Application for a non-material amendment following a grant of planning permission.

Single storey extension to front.	
Reference number:	BR/136/20/HH
Date of decision	17/08/2020

PROPOSED ELEVATIONS

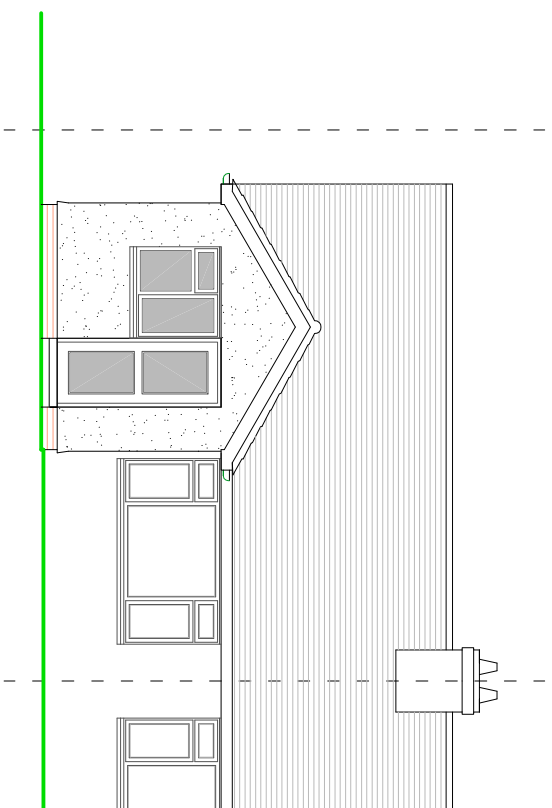
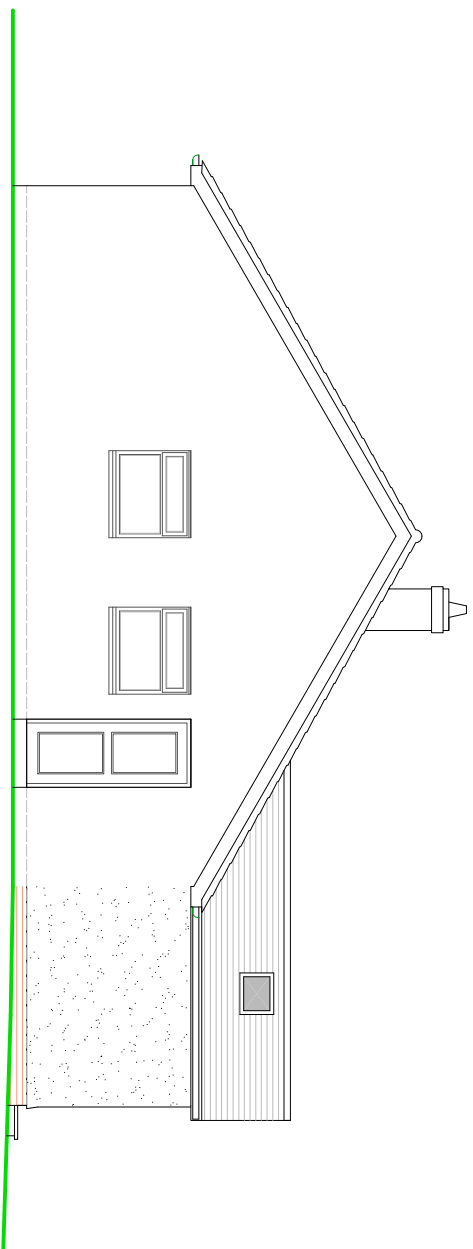
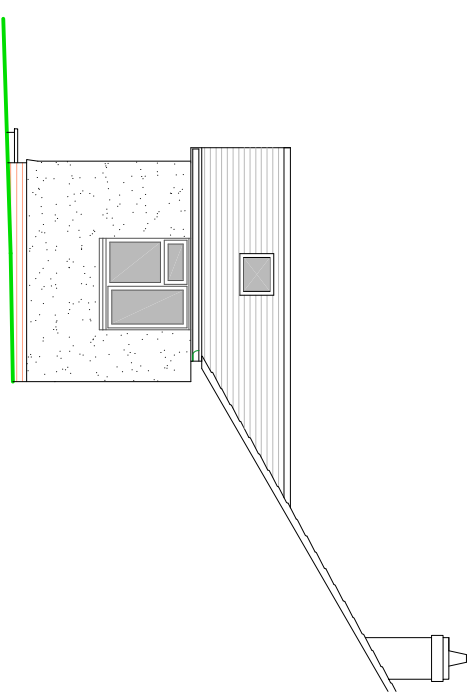
Change from face brick to painted render finish for walls.

Old plan/drawing numbers

Proposed Elevations - Rev A - 01/07/2020

New plan/drawing numbers

Proposed Elevations - Rev B - 21/09/2020
